**RECORD
DOCUMENTS**

**POND GRADING
PLAN**

C7.4

C7.4

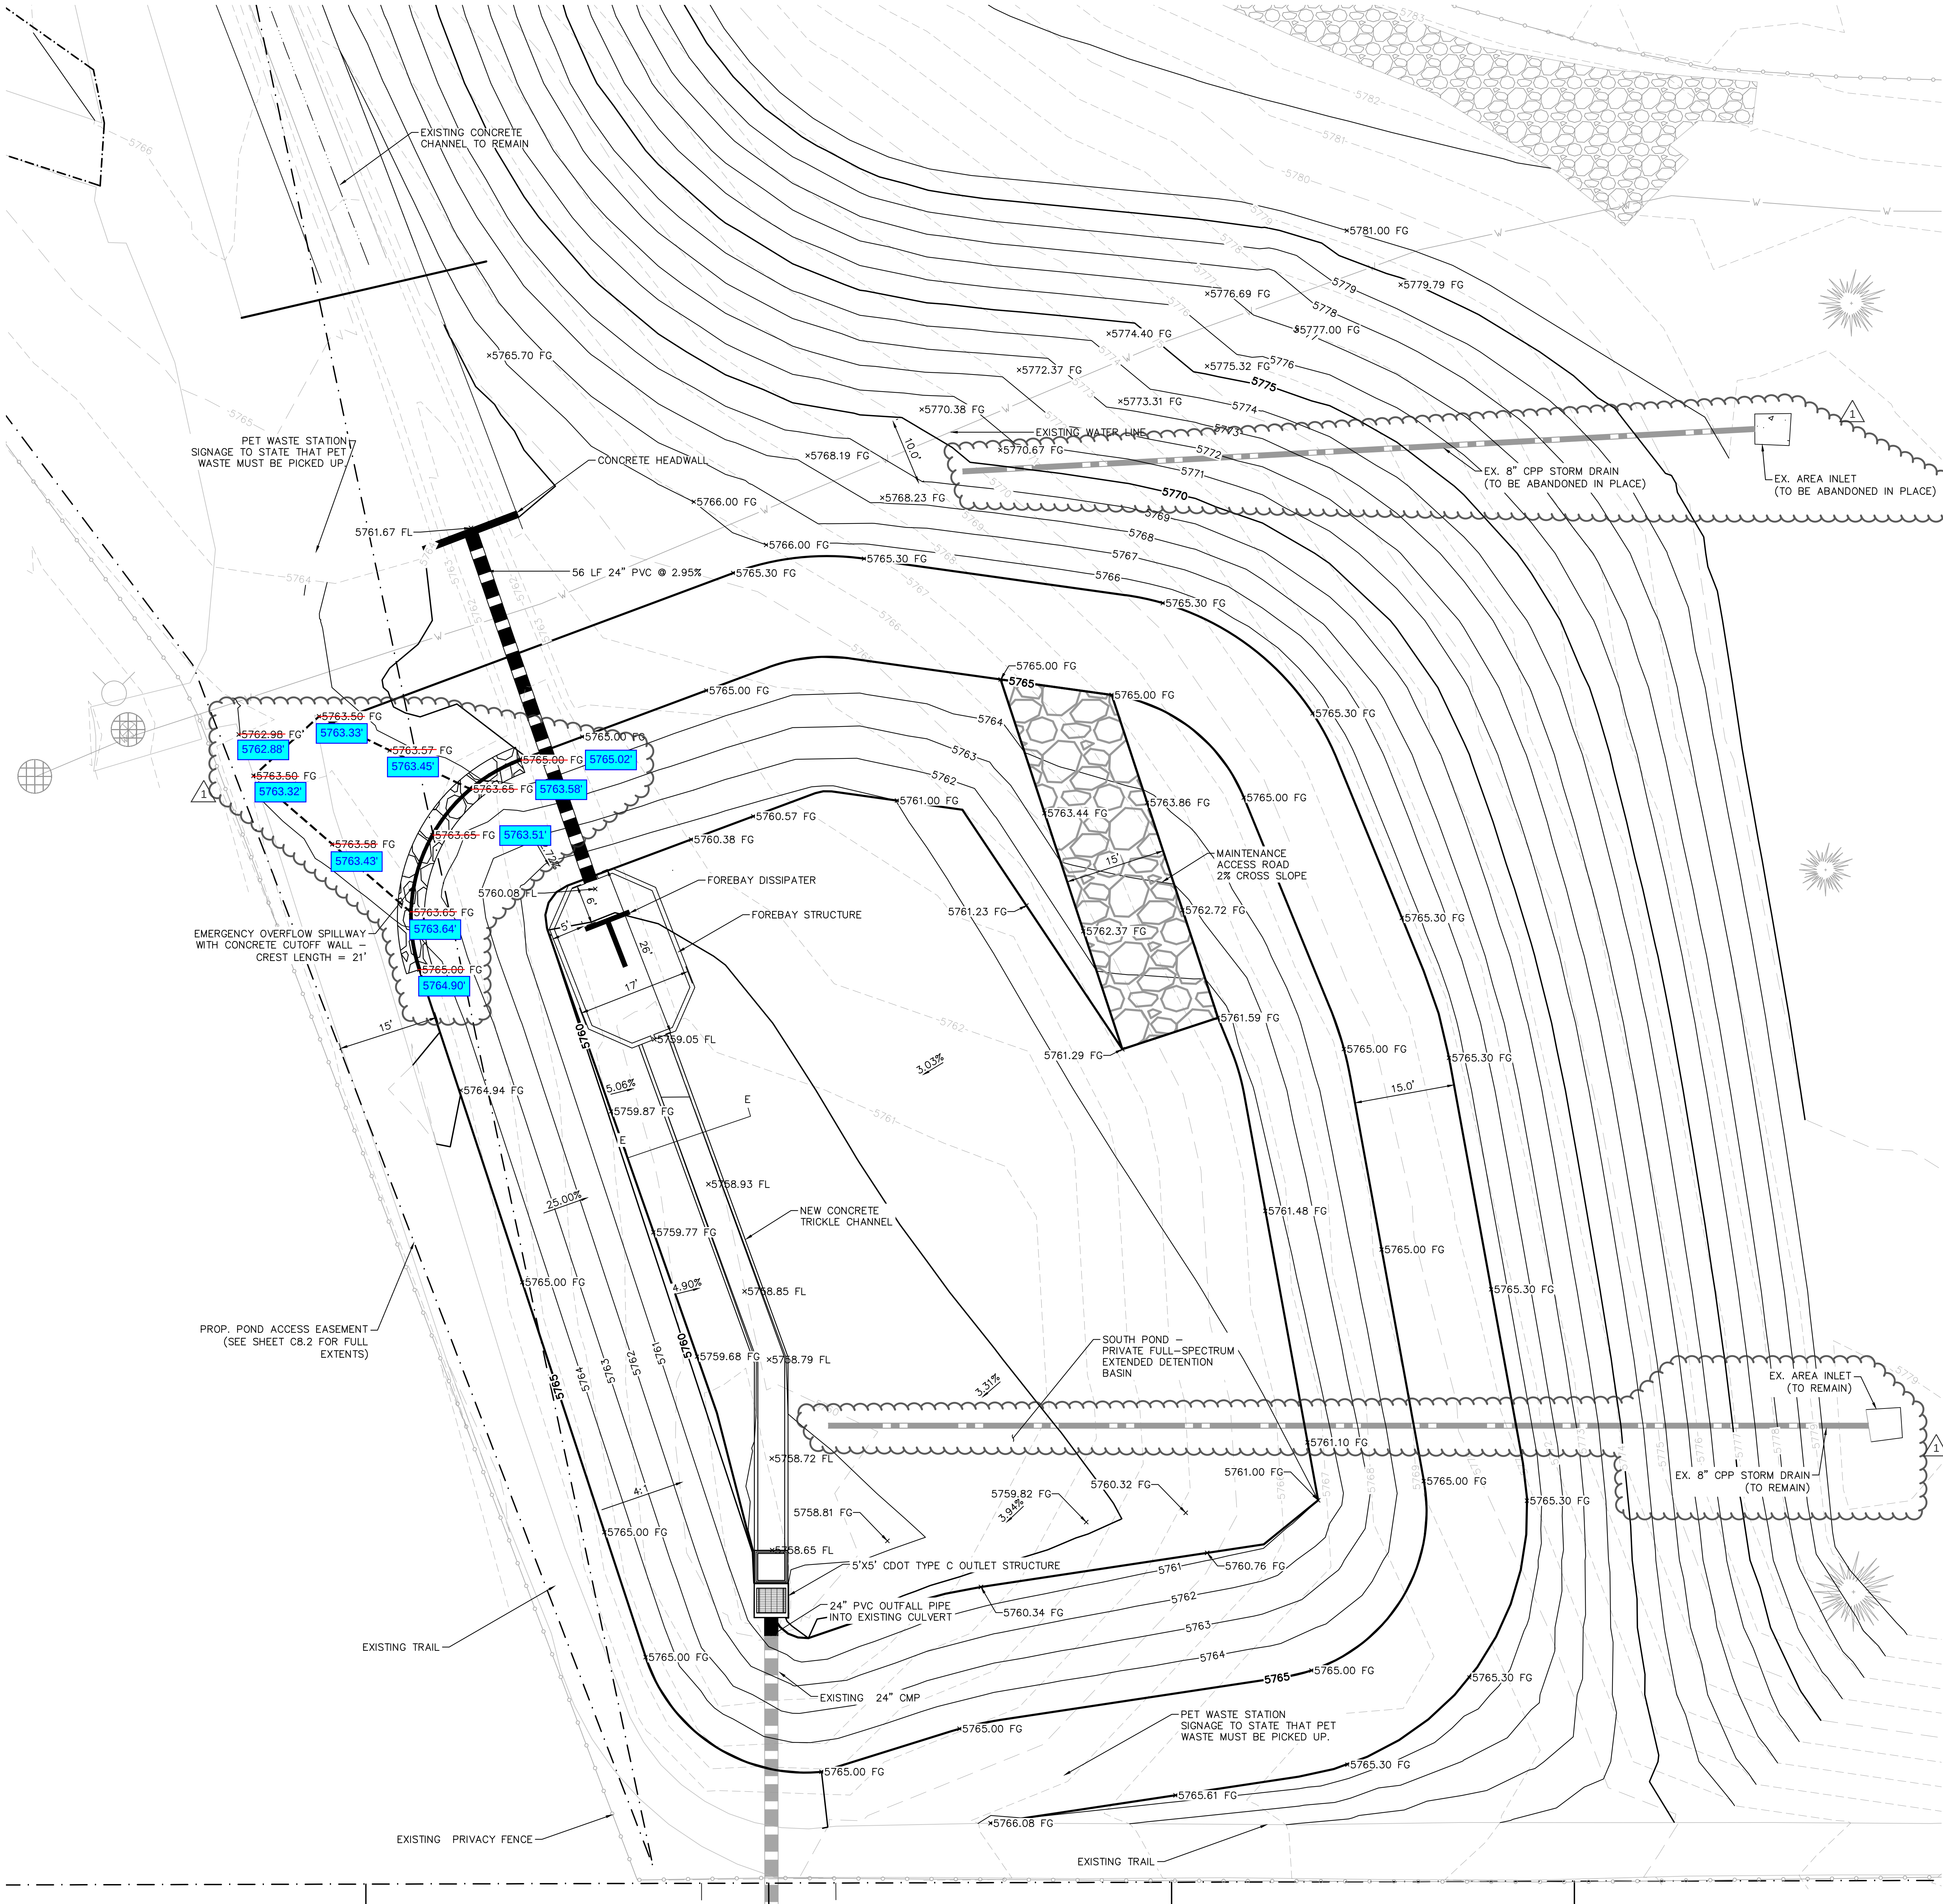
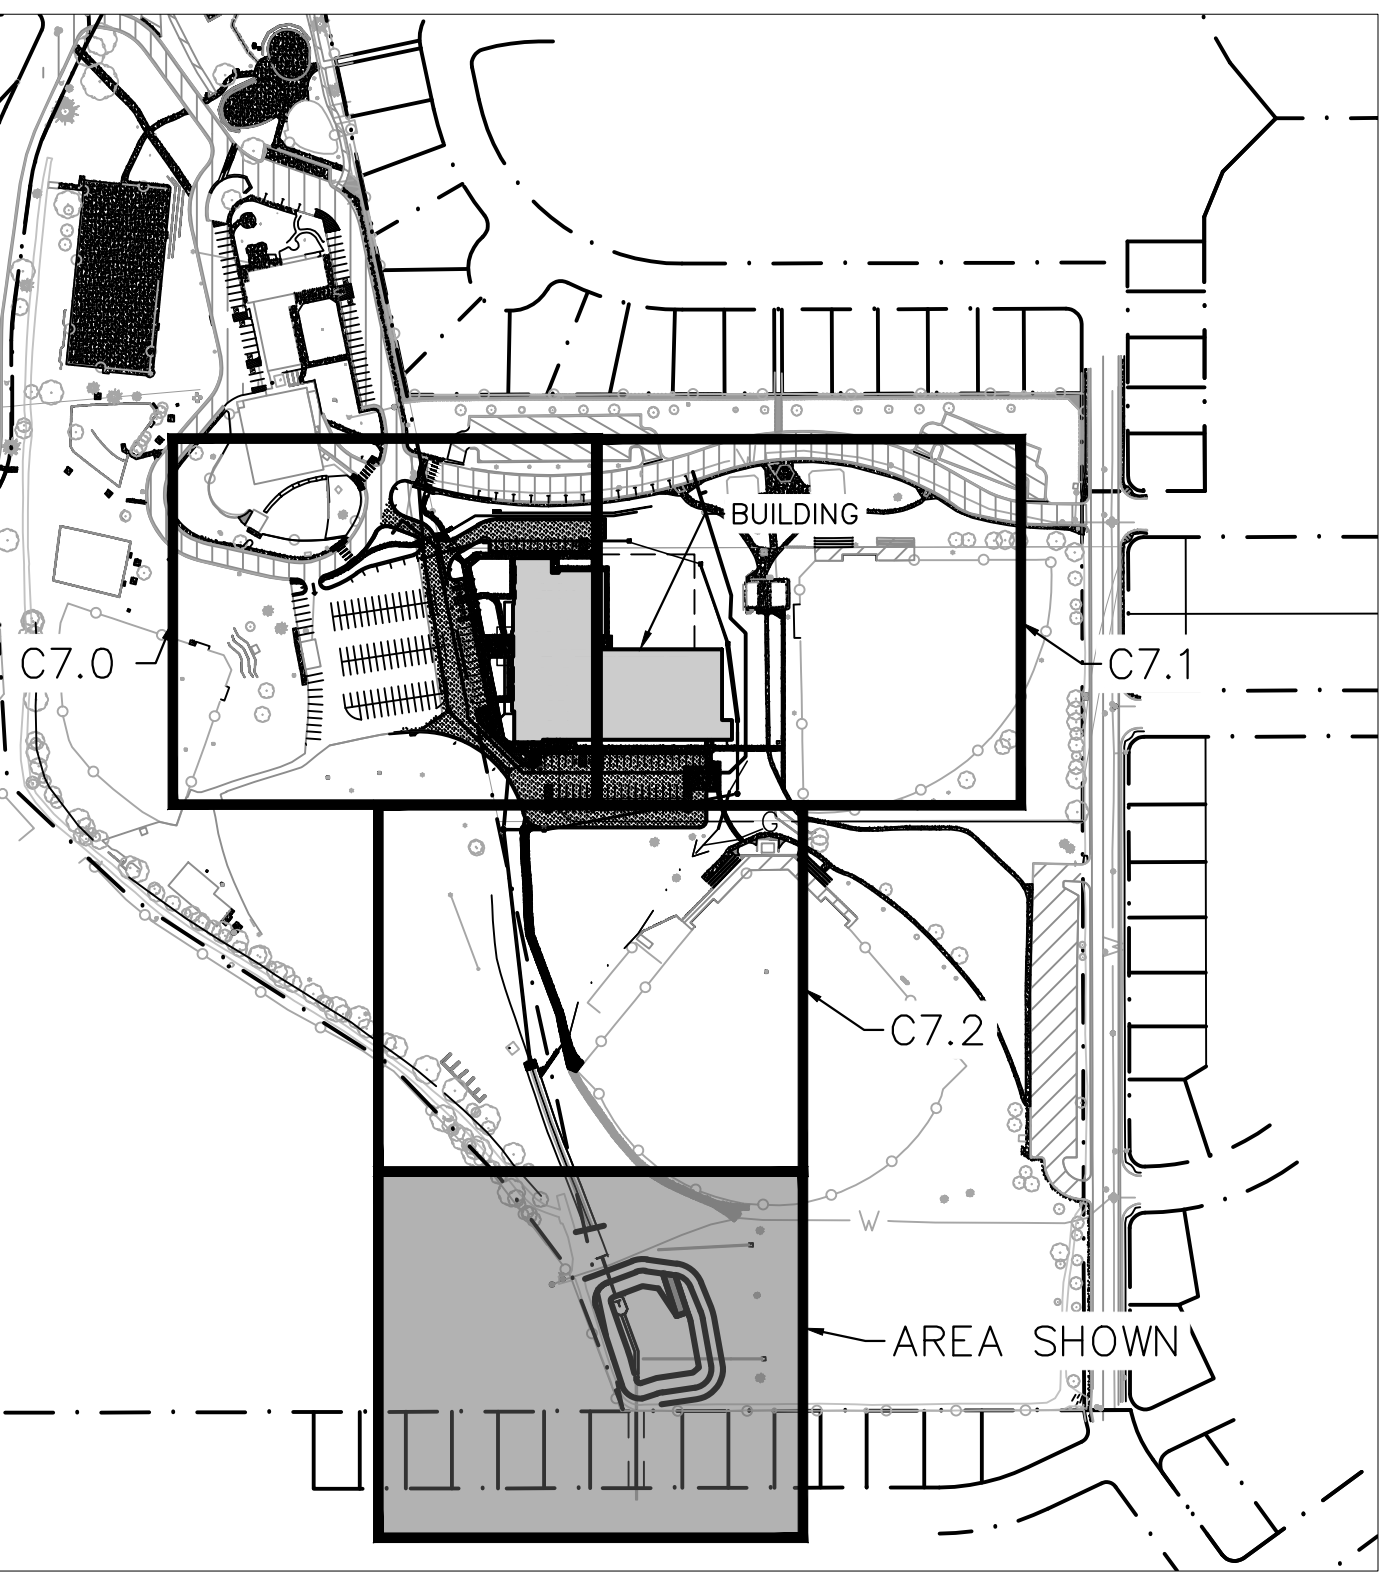
Unresolved Review 1 comment: please be consistent with your as-built colors. There's like 3-4 different colors on your markups. Industry standard is to just use red for all as-built markups.

Per ECM 5.10.6, label each sheet as "As-Built" or "Engineer Record Drawings" with EOR stamp and signature.

Northeast of building. Vegetation has not met requirements. Grading plan shows vegetation in this area but about 1/2 acre of gravel is present. Show on As Builts and update pond calcs or remove gravel and revegetate.

Please discuss with the developer on how they would like to proceed. If they want to remove the gravel and revegetate this area as shown on the approved plans, then no as-built action is needed on your part. But if they would like to leave it as gravel, you will need to look at the runoff and pond calcs and submit them for our review with this ASB project. Include a discussion of your findings/revisions of this research in your Pond Cert Letter (in the case of the developer not wanting to revegetate).

Review 1 unresolved comment: part of the as-built process is redlining items that were not installed per plan, like the microscreen.

Review 2 update: just callout here the make/model of the version that was installed and which you have submitted a spec sheet for.

You should have a callout here that references your multi-colored detail that shows the as-built condition of this. And then add that in as a page to this document.
